Reply to Jeanie Bourke's review comments for proposed Baxter Academy at 54 York St
Portland ME .

CBL: 042 A0070 **Permit ID:** 2012-45504

4/11/2013-JMB/Building:

A1.3

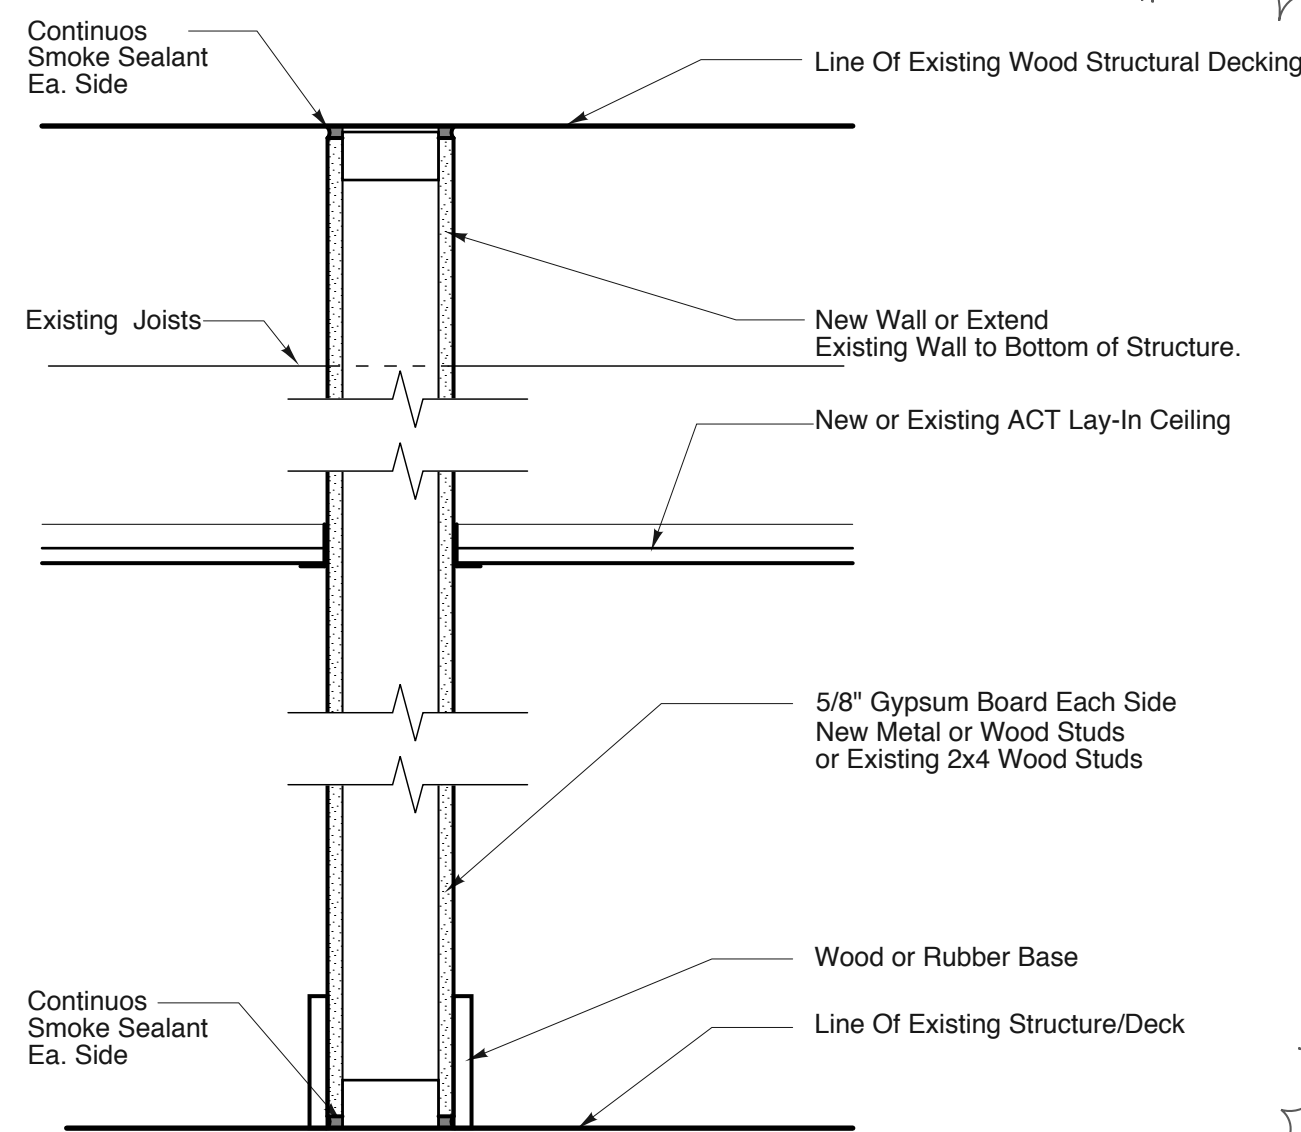
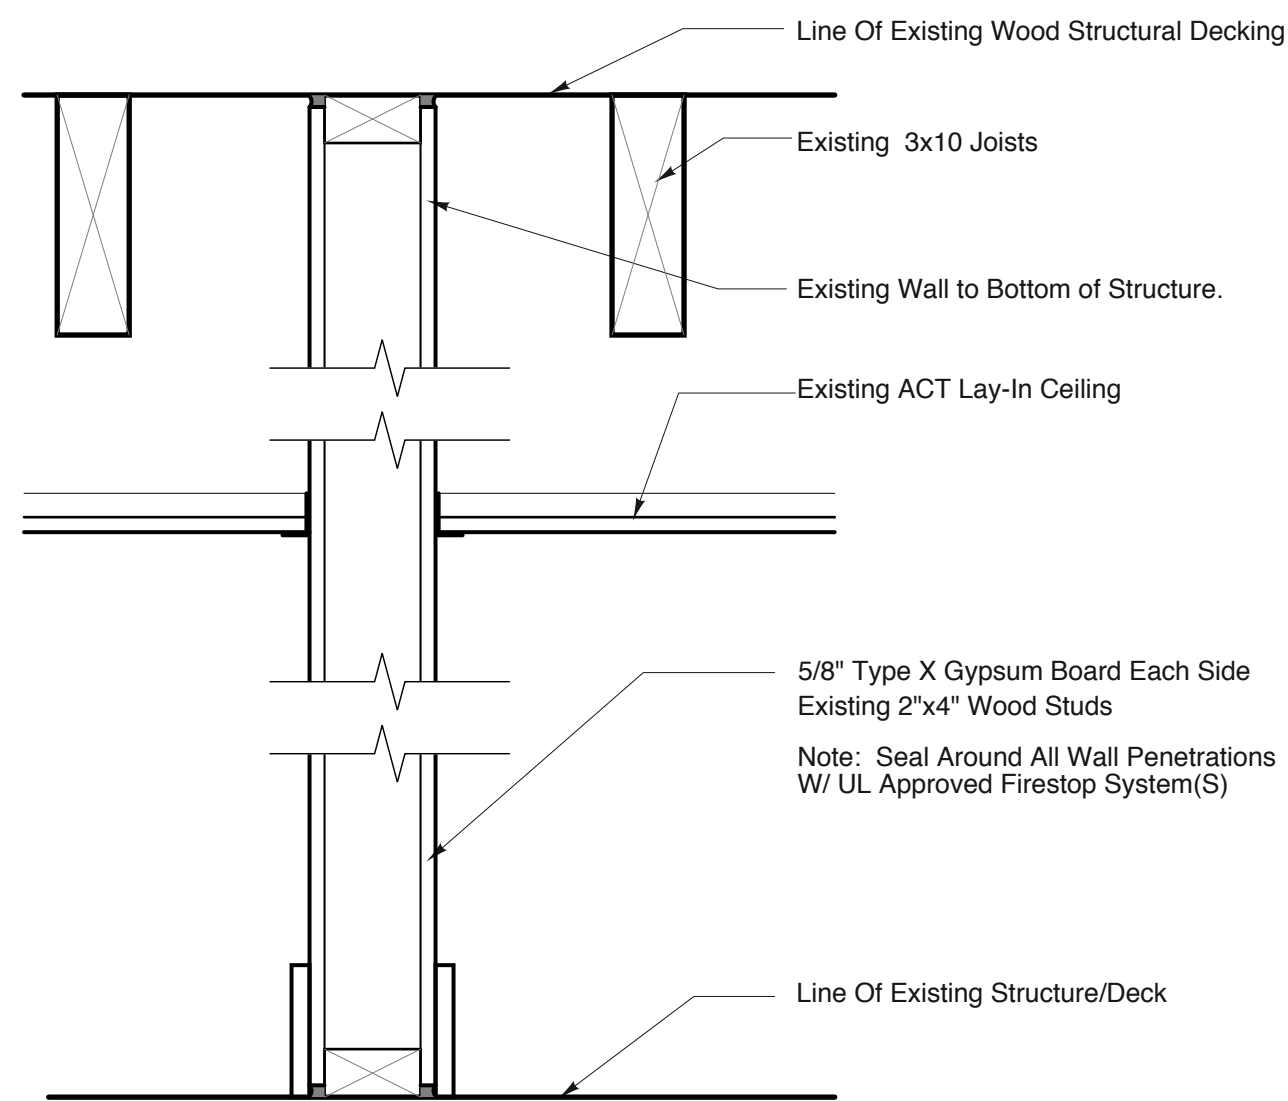
1. Plan CS - floor 1, when rooms 101 & 102 are combined the occupant load is over 49. Per IBC Sec. 108.1.2 doors shall swing in the direction of travel, and Sec. 1008.1.10 panic fire exit hardware is required.
2. Please clarify the contents mechanical closet room 101 as the door is not specified to be smoke tight.
3. The basement area is noted as storage, mechanical, and tenant space, clarify this and provide the code analysis for required fire separation of this use and area.
4. The 2nd floor phase 2 area is noted as unoccupied general storage. Clarify if this area will be sprinkled and evaluate if this is allowed as a non separated mixed use area per Sec. 508.3

1. We will revise door swings and provide fire exit hardware.

2. We will revise door hardware to include smoke seals. Our office is not certain at this time as to the exact contents of that room. The building owner is providing all MEP and fire protection design independently.
